Rezoning Transportation Analysis

Petition Number: 2020-025

Date	Description
02-15-2020	First Review
03-25-2020	Second Review

SHEET NUMBER  
**RZ-1**

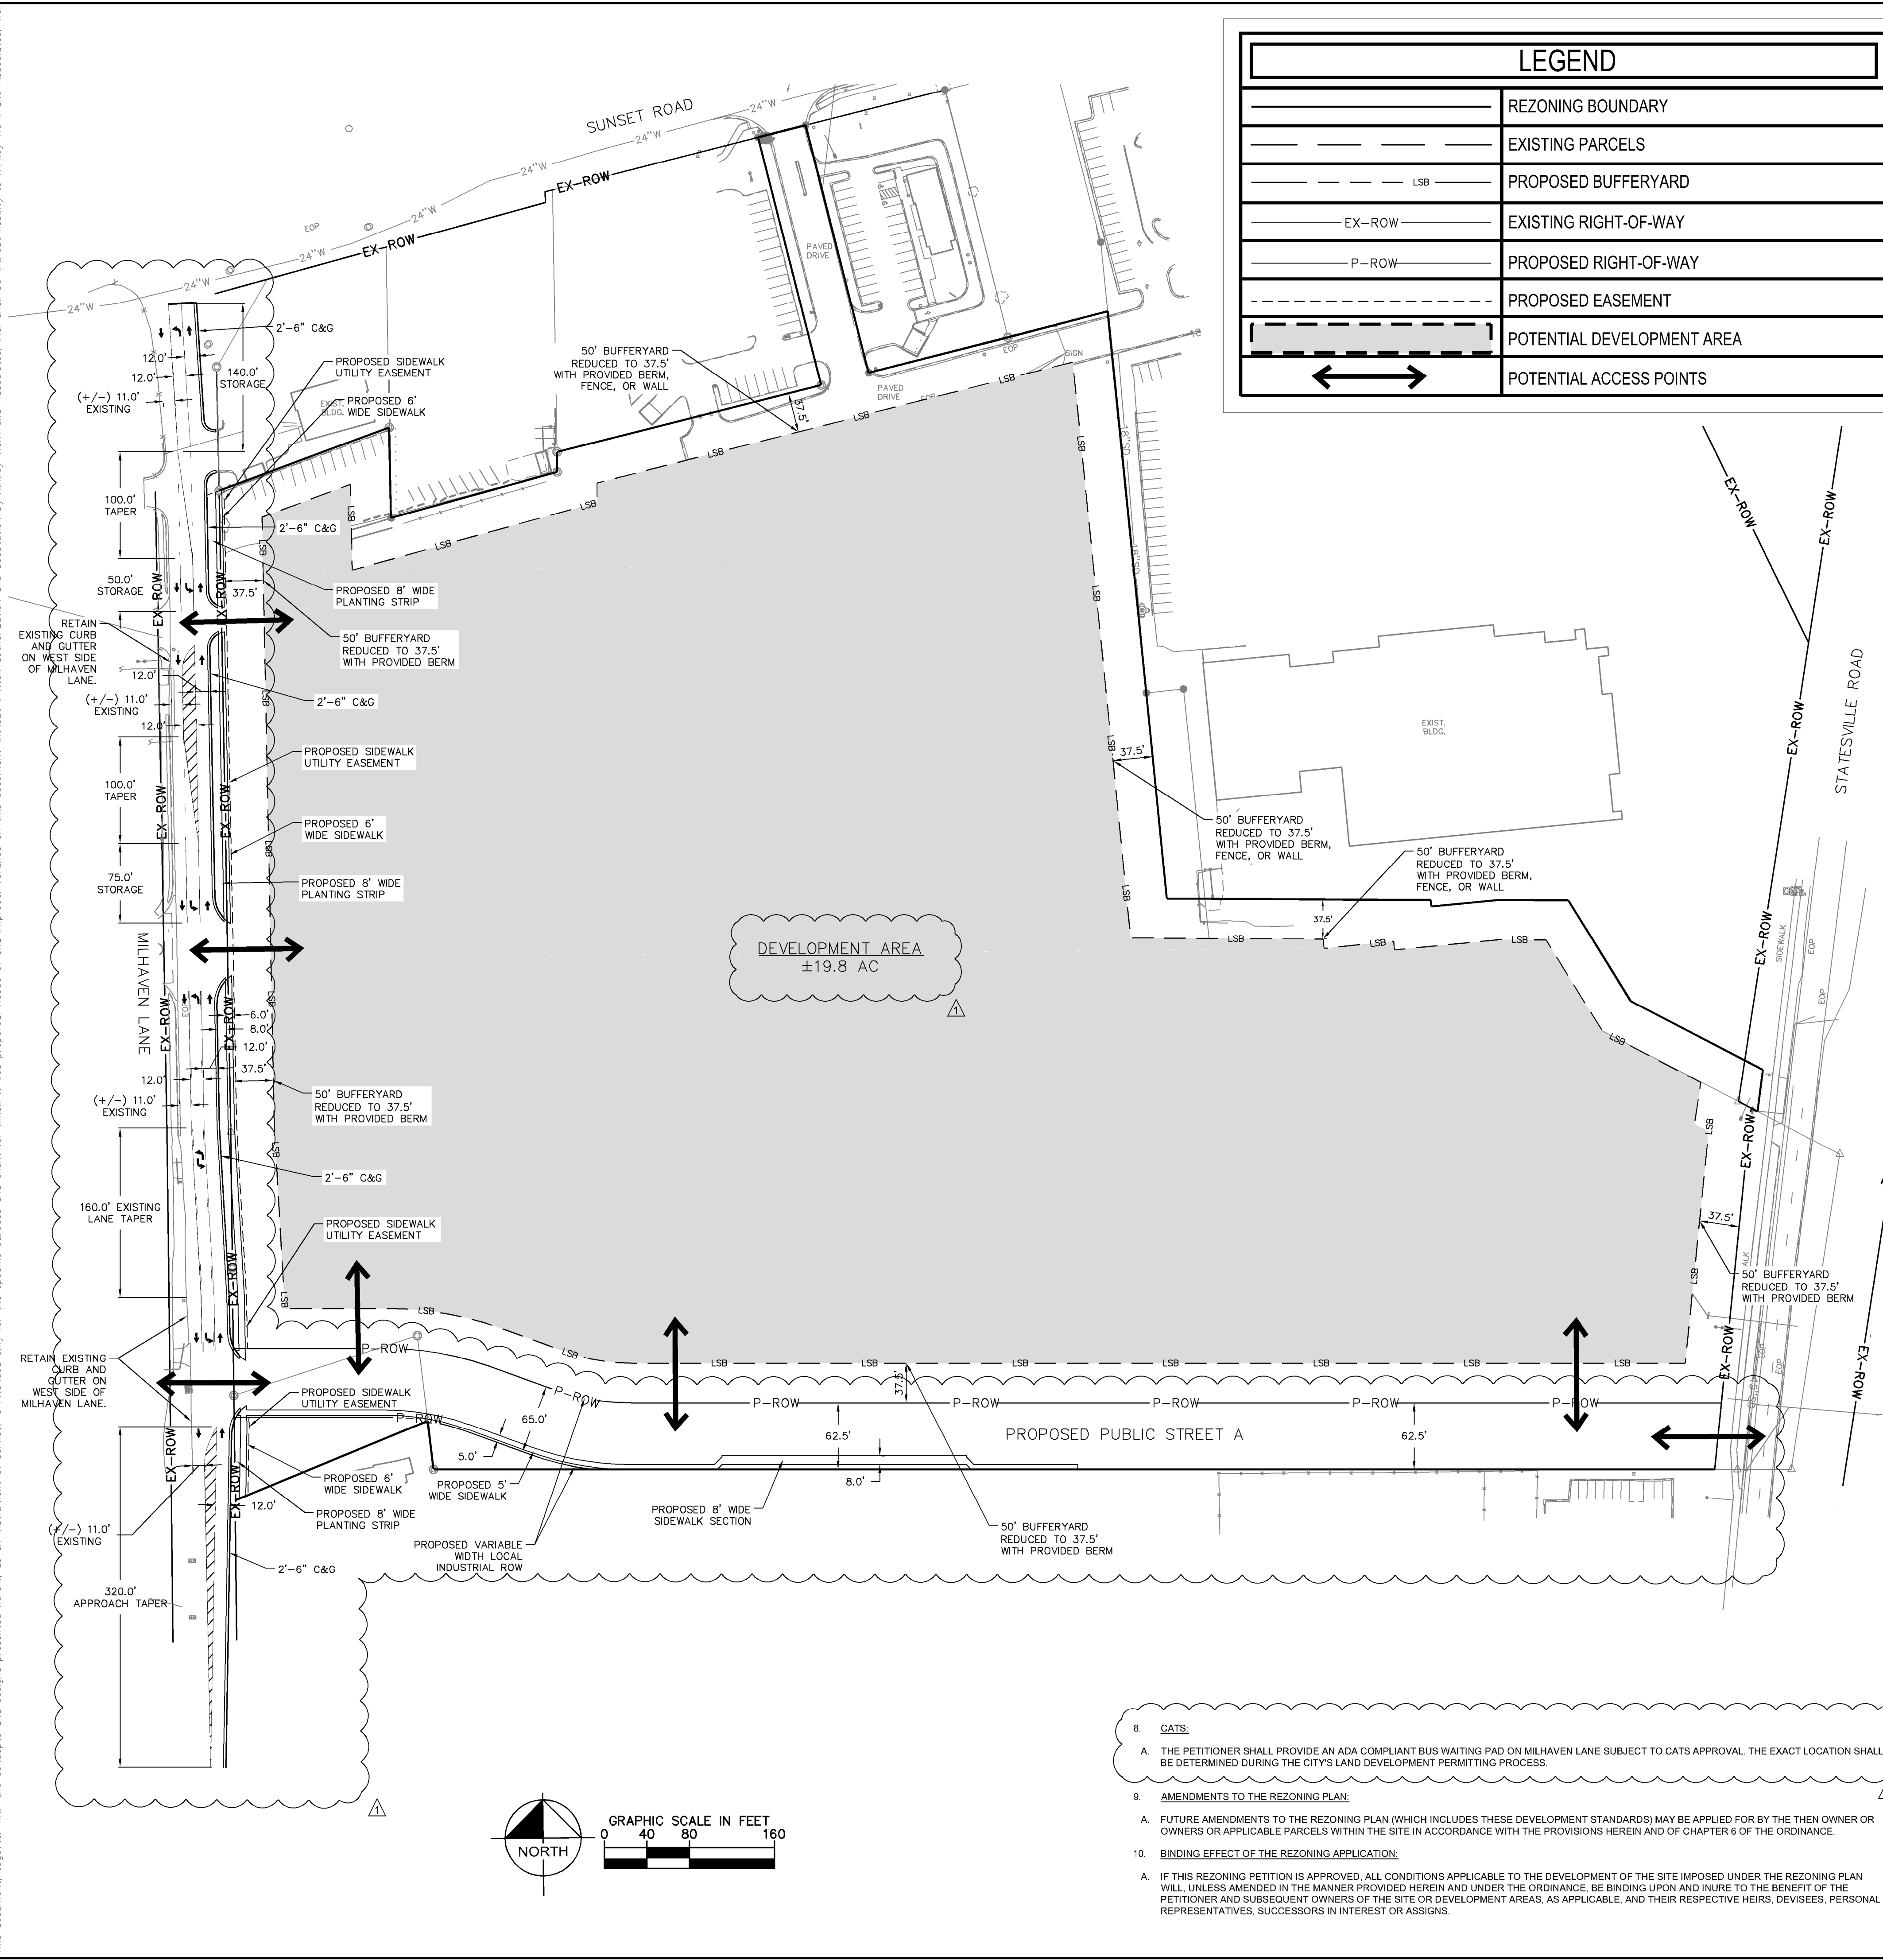
- ~~1. Millhaven Lane is an existing collector road and should provide the typical for a collector road. The petitioner should revise the site plan and conditional note(s) to place the curb and gutter along Millhaven Lane at a consistent 3-lane section (see below) across the property frontage without tapering the curb and gutter.~~

- ~~2. **Traffic Study** A Traffic Impact Study is not necessary for the complete review of this petition. If during the permitting process the site generates more than 2500 daily trips, then a traffic study will be required.~~
- ~~3. The petitioner should revise the site plan and conditional note(s) to provide additional storage for the existing left-turn storage at Millhaven Lane onto Sunset Road. The existing left-turn lane is only 97' long and the proposed traffic will generate truck traffic that will utilize the capacity.~~
- ~~4. The petitioner should revise the site plan and conditional note(s) to add a left turn on Statesville Road to site aligned across from Keith Drive.~~

5. Technical Correction: The petitioner should revise the site plan and conditional note(s) to remove the northern driveway on Millhaven Lane or restrict access to exit only to avoid conflict points with the access across the street.
 - a. **Technical Correction Based on Revised Site Plan** The petitioner should revise the site plan and conditional notes to restripe Millhaven Lane as shown on the exhibit below, in order to keep the proposed full access near the norther property line.

6. The petitioner should revise the site plan to add a note specifying dedication and fee simple conveyance of all rights of way to the City before the site's first building certificate of occupancy is issued. CDOT requests right of way set at 2' behind back of sidewalk where feasible.
7. The petitioner should revise the site plan to add a note specifying all transportation improvements will be approved and constructed before the site's first building certificate of occupancy is issued. The petitioner may phase transportation improvements if said improvements and phasing are explicitly described in site plan notes.
8. **Resolved** Sample format for comment that is resolved
